Our ref: OUT25/8157

Subject: Hillview Hard Rock Quarry (SSD-70557215) – Environmental Impact Statement

### Detailed advice to DPHI Planning & Assessment regarding the Hillview Hard Rock Quarry (SSD-70557215) – EIS

Hi\Projects-SLR\630-Sr\NTL\630-NTL\630.12117 Hillview Quarry EIS\06 SLR Data\01 Drafting\CAD\CATCHMENT PLANS 2023\JJ\630.12117 - SK01 to SK08 (REV A).dwg

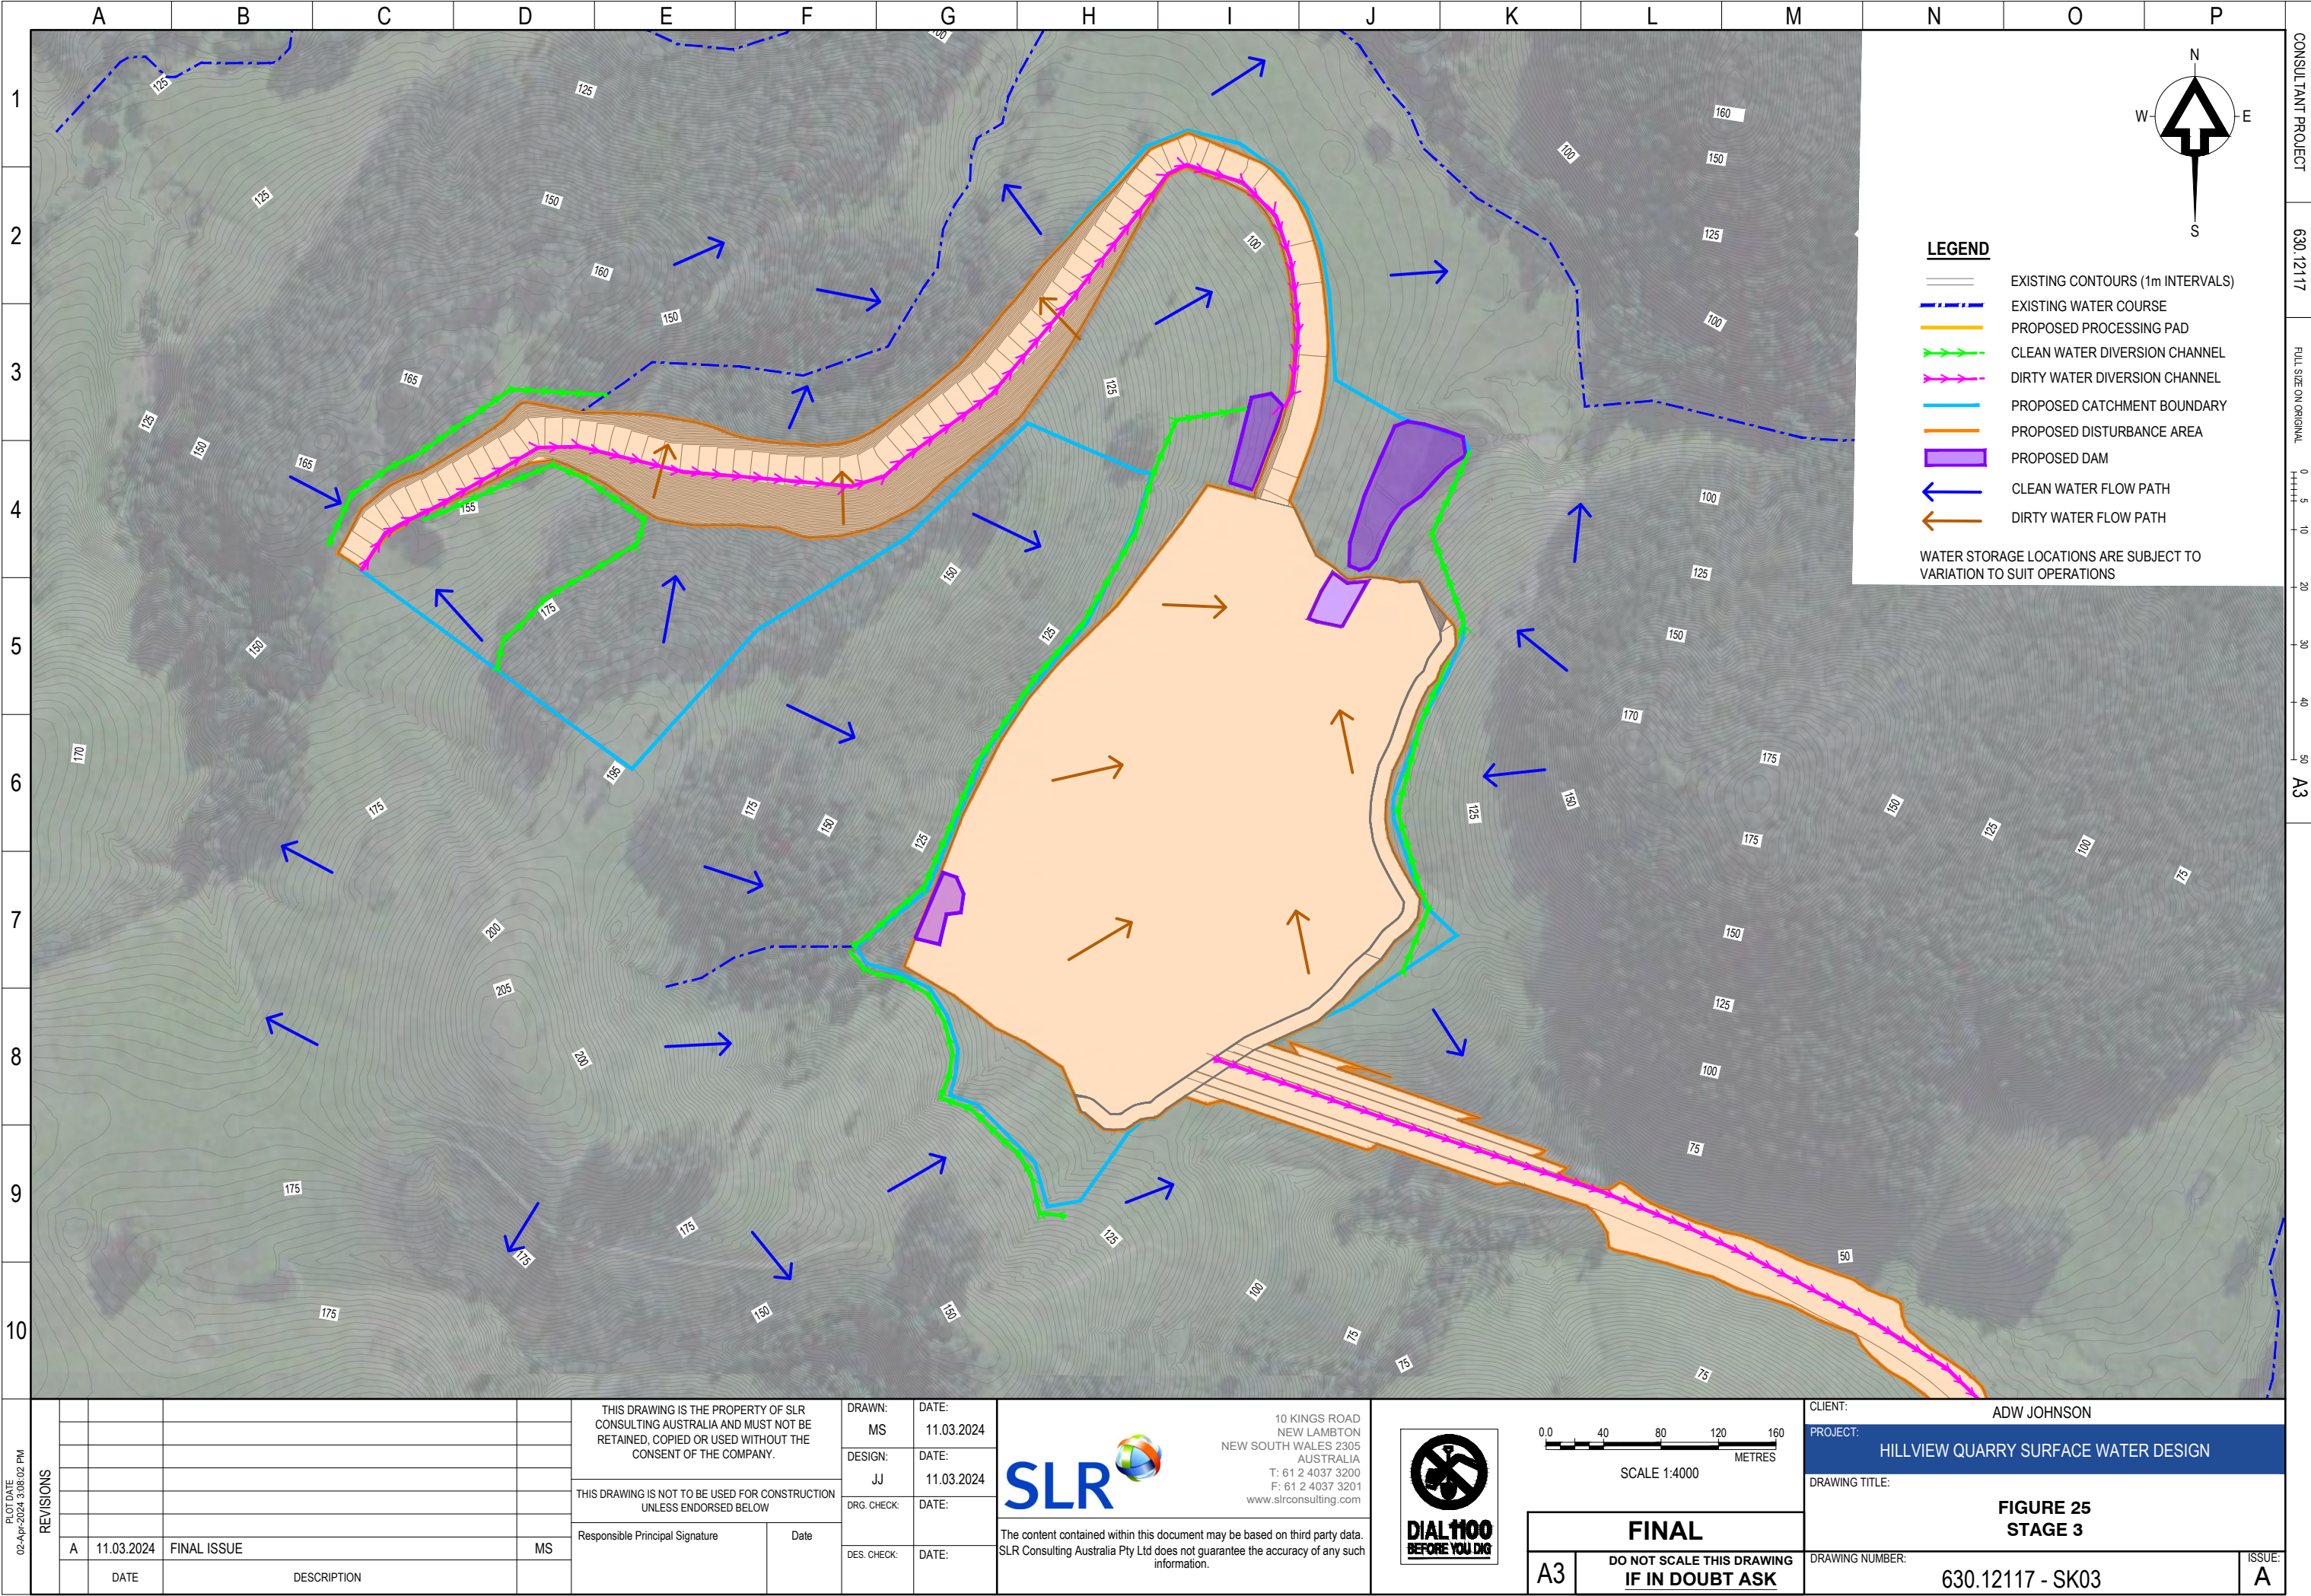
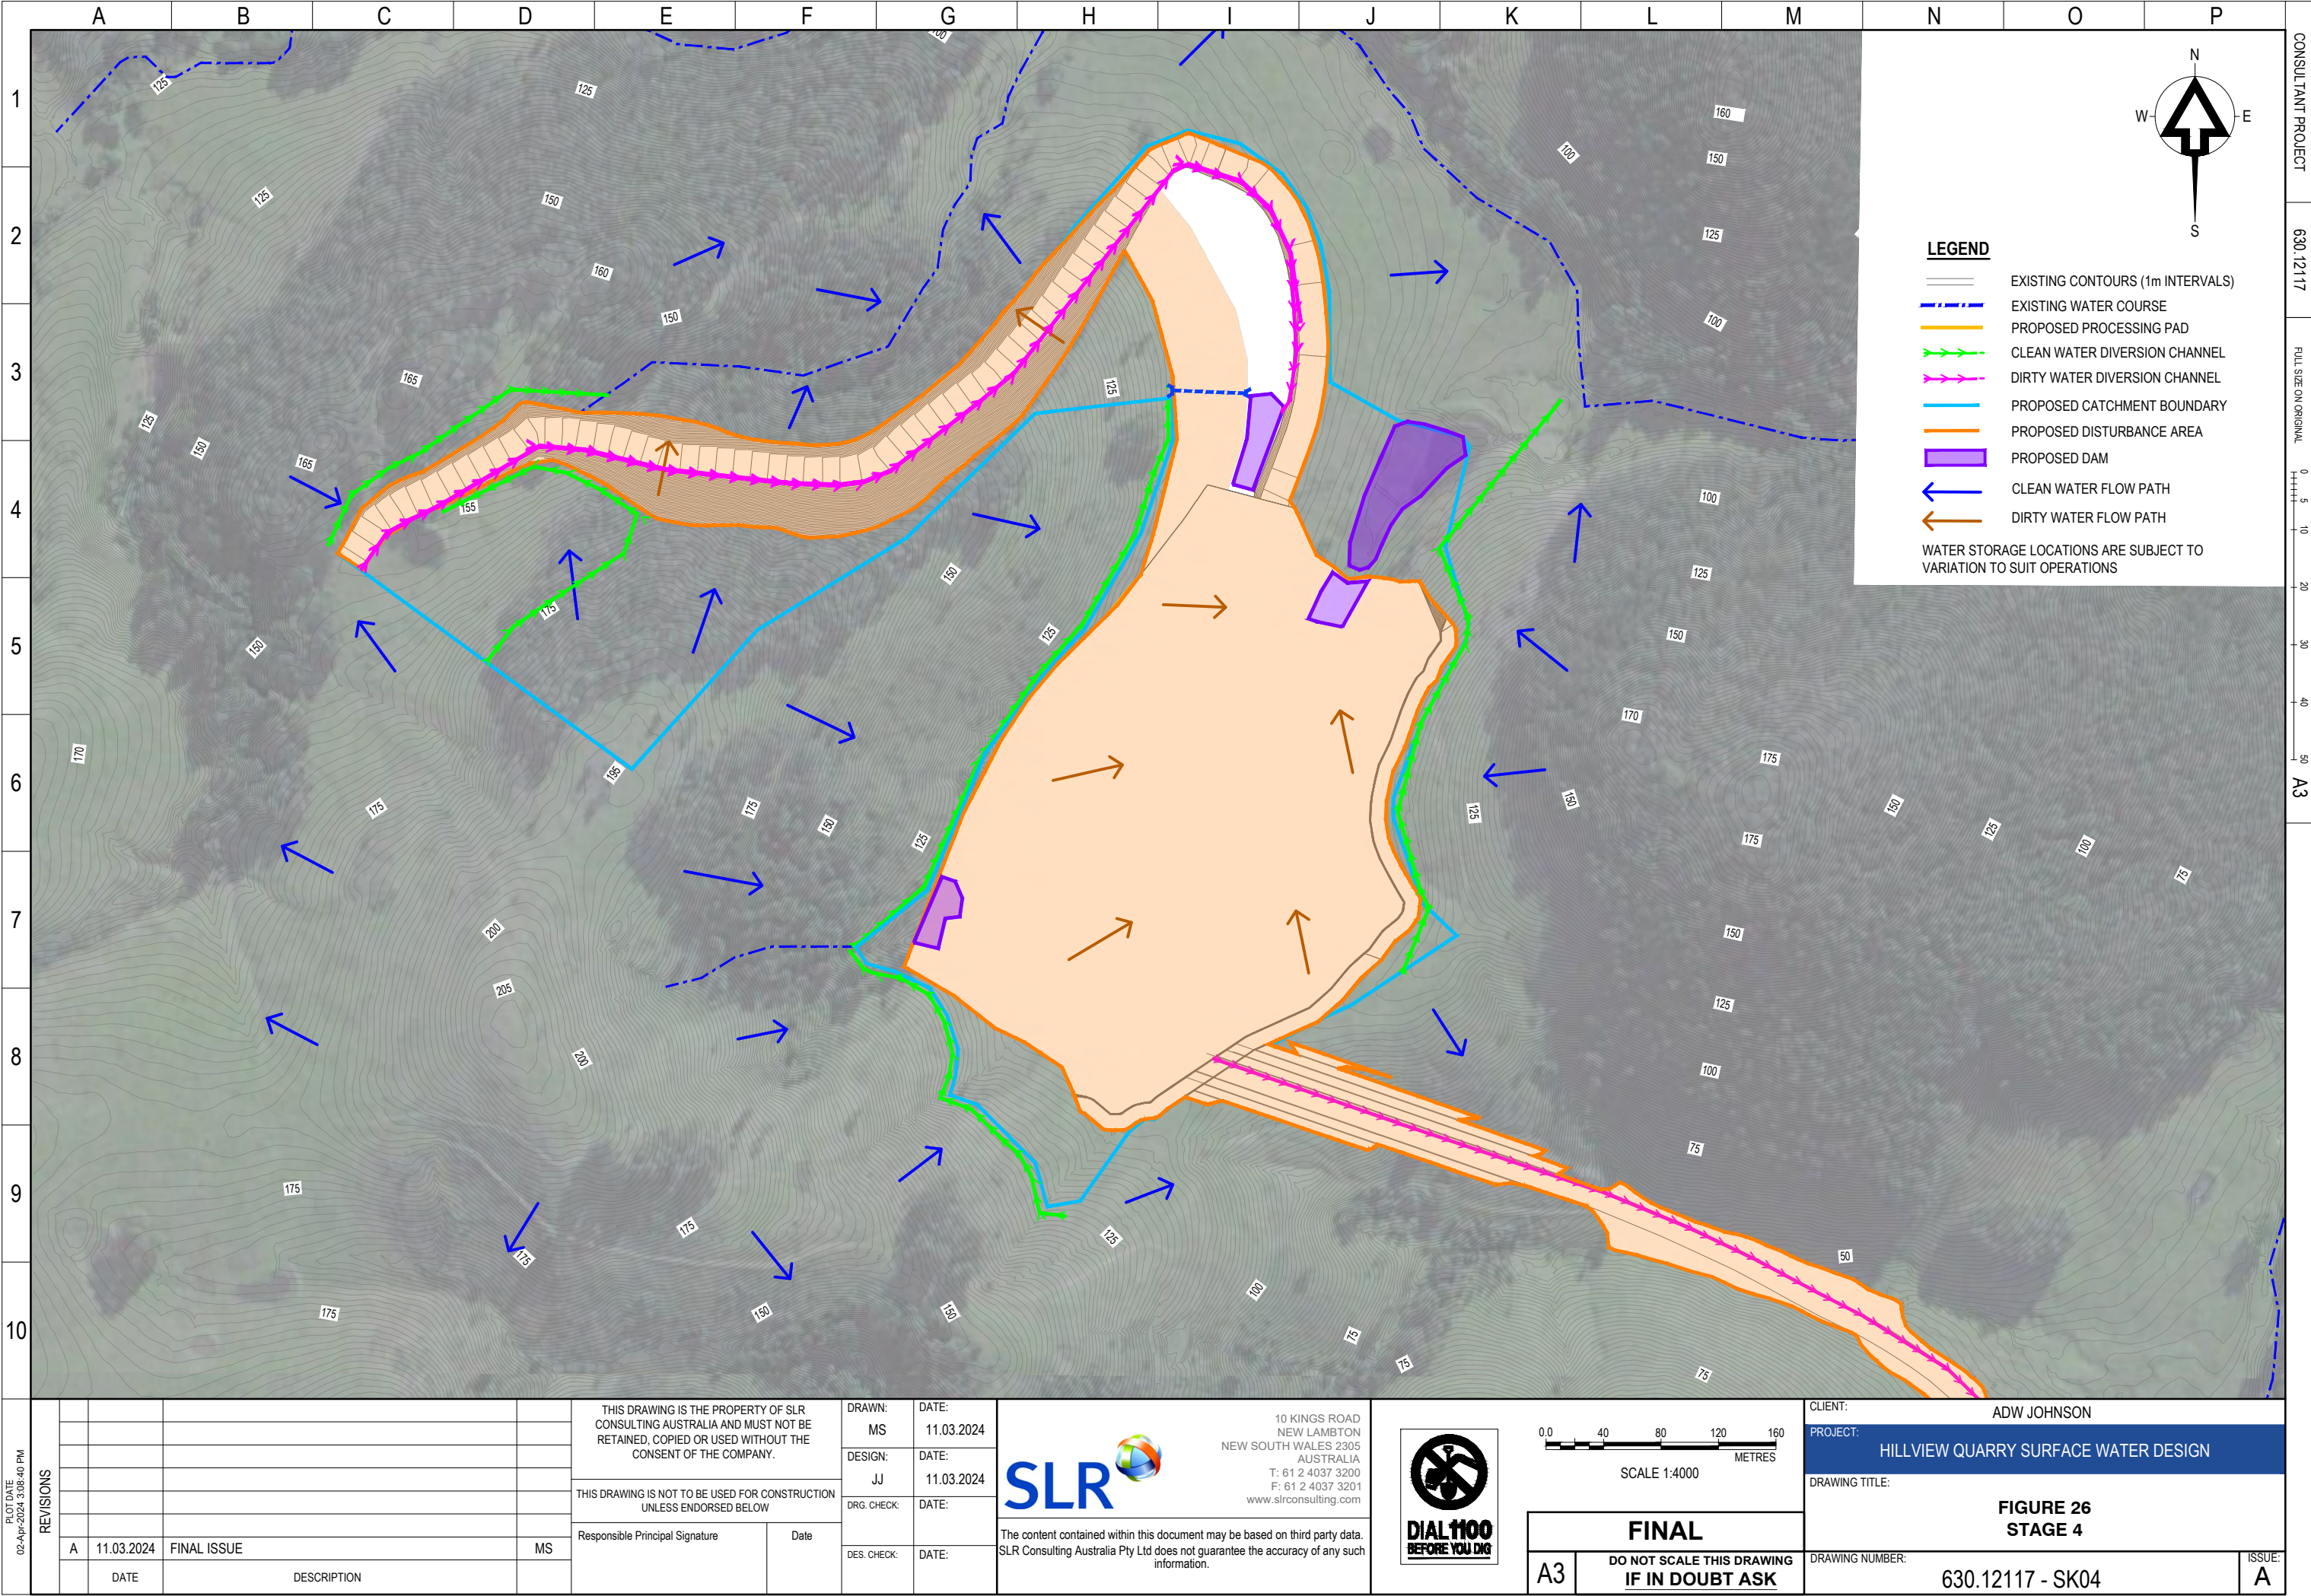
The proposal includes several dams/basins which need to be considered against the water licensing framework. This should consider the harvestable rights capacity, exclusions under Schedule 1 of the *Water Management (General) Regulation 2018* or the requirement to obtain entitlement. Figures 24-29 and 49 of the Surface Water Assessment show that an existing 'Farm Dam' is proposed to be converted to a sediment dam at the outlet of the quarry. This dam is on a third order stream so would not meet the definition of an excluded work under Schedule 1 of the WM (General) Regulation as it is not located on a minor stream.

Dams on third order watercourses do not meet the Departments Guidelines for Controlled Activities on Waterfront Land – Riparian Corridors. It is generally requested that water quality treatment occurs offline.

The Department of Planning, Housing and Infrastructure request the proponent to review the proposed surface water structures to confirm the requirement for water licensing or where an exemption may apply. This is to include a review against:

- The excluded work provisions under Schedule 1(4) of the Water Management (General) Regulation 2018. Further information is available at: [https://water.dpie.nsw.gov.au/\\_data/assets/pdf\\_file/0008/554444/excluded-work-exemption-fact-sheet.pdf](https://water.dpie.nsw.gov.au/_data/assets/pdf_file/0008/554444/excluded-work-exemption-fact-sheet.pdf)
- Maximum harvestable rights dam capacity where dams are located on minor streams and capture runoff.
- The requirement for licensed entitlement where the water capture/use is not exempt or excluded, and to demonstrate this can be obtained in the relevant water source.
